From: Amy Myer <Amy.Myer@arun.gov.uk>
Sent: 01 December 2021 12:26
To: Planning.Responses <Planning.Responses@arun.gov.uk>
Cc: Juan Baeza <Juan.Baeza@arun.gov.uk>
Subject: FW: FG/183/21/HH - 52 Ocean Drive - WITHDRAWN

I note that the site is located in Flood Zone 3 (high risk from coastal sea flooding) but that no Flood Risk Assessment (FRA) has been submitted with the application.

Elevations
as Proposed

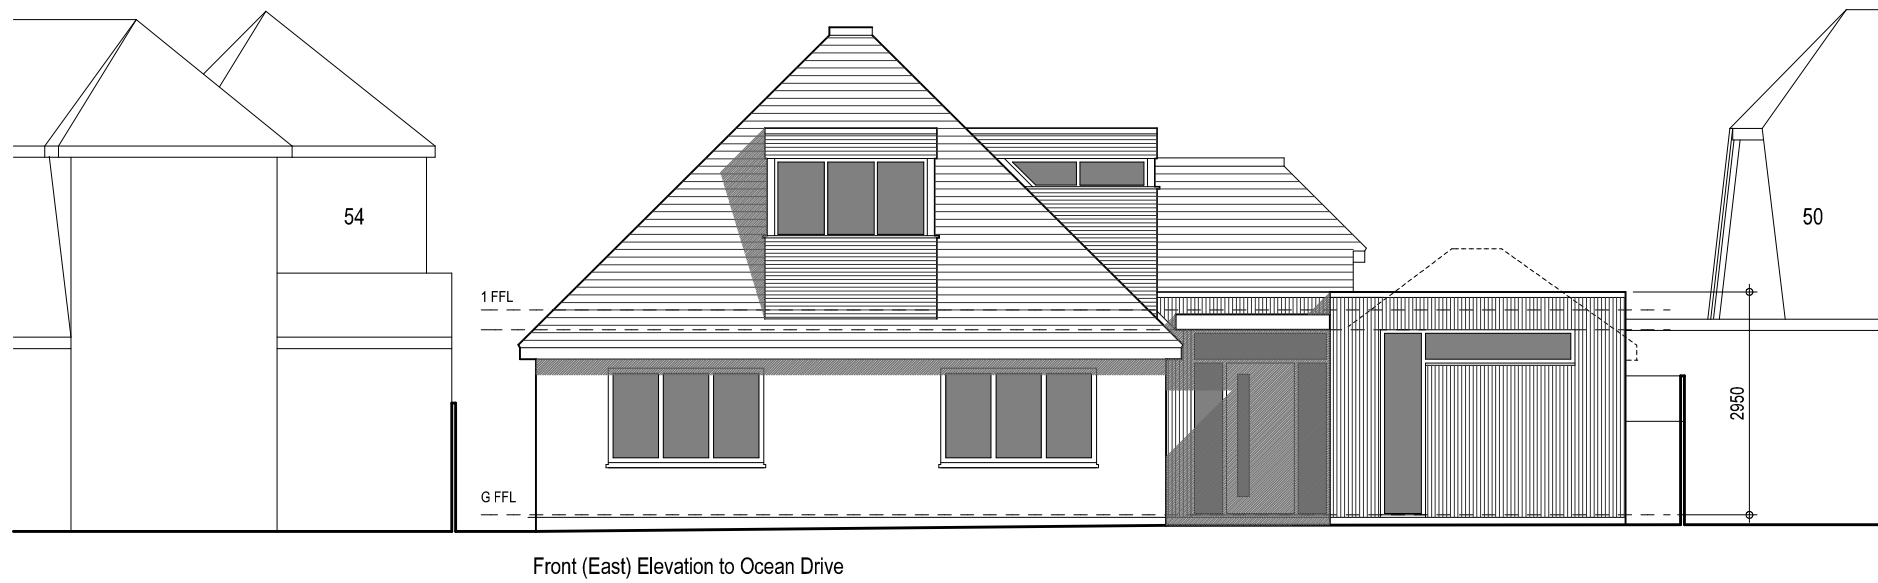
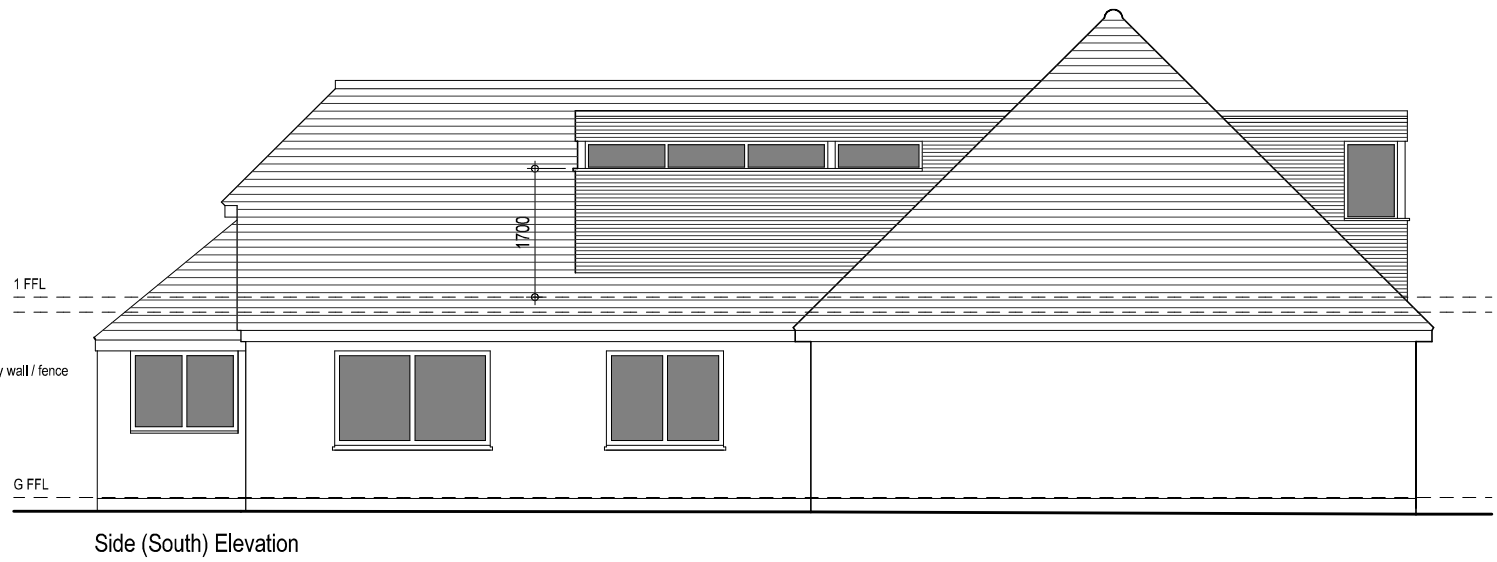
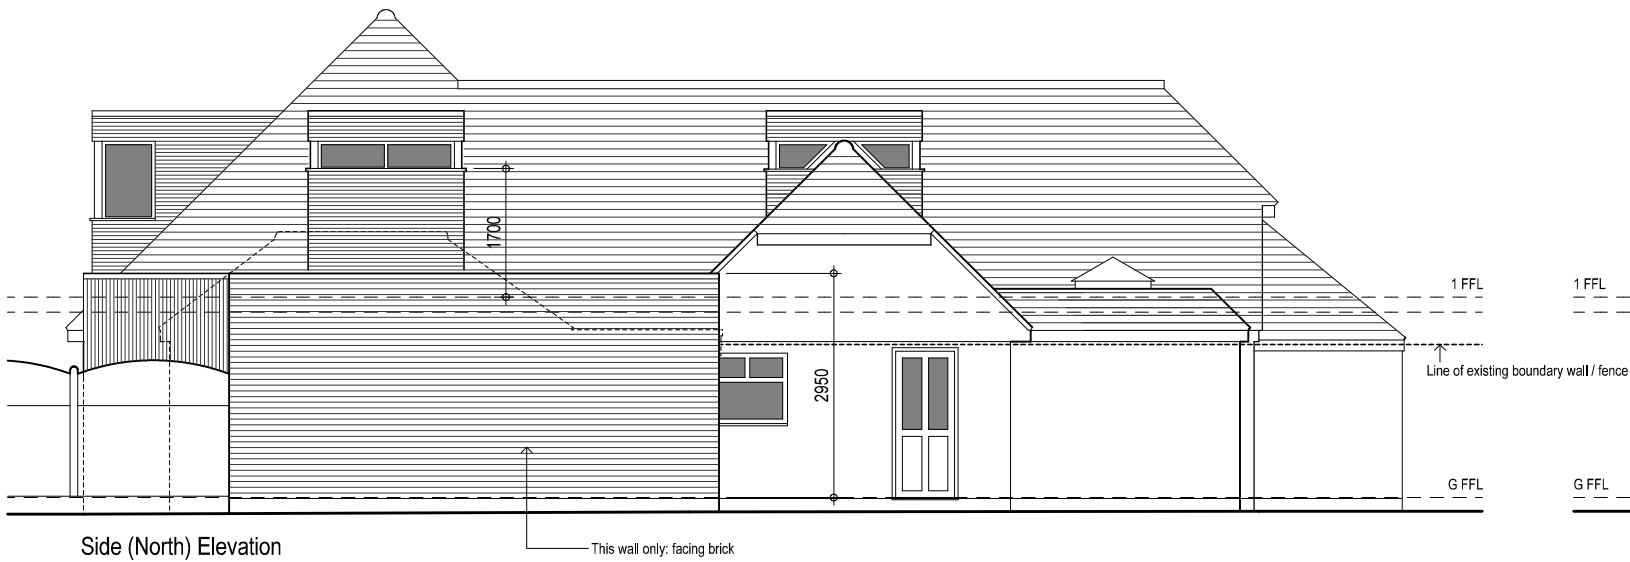
As such, without an FRA and EA consultation, we would unfortunately have to recommend refusal of the current application. In addition, I have concerns that the front dormer is overly bulky i.e. the flat roof and window part may be OK but that the underneath part extends too far down appearing unnecessarily bulky and not subordinate in the roof i.e. should stop short just under the lower window sill. The side dormer on the northern elevation equally should be set further up from the eaves. I also wonder if these could be designed with pitched roof forms instead to have a more charming

appearance than 'boxes'. These should appear as small proportional additions which do not dominate the roof form, given the existing roof scape along this area and modest small dormers.

I would suggest you therefore withdraw the current application and re-submit with an FRA and revised drawing to address the visual impacts of the dormers.
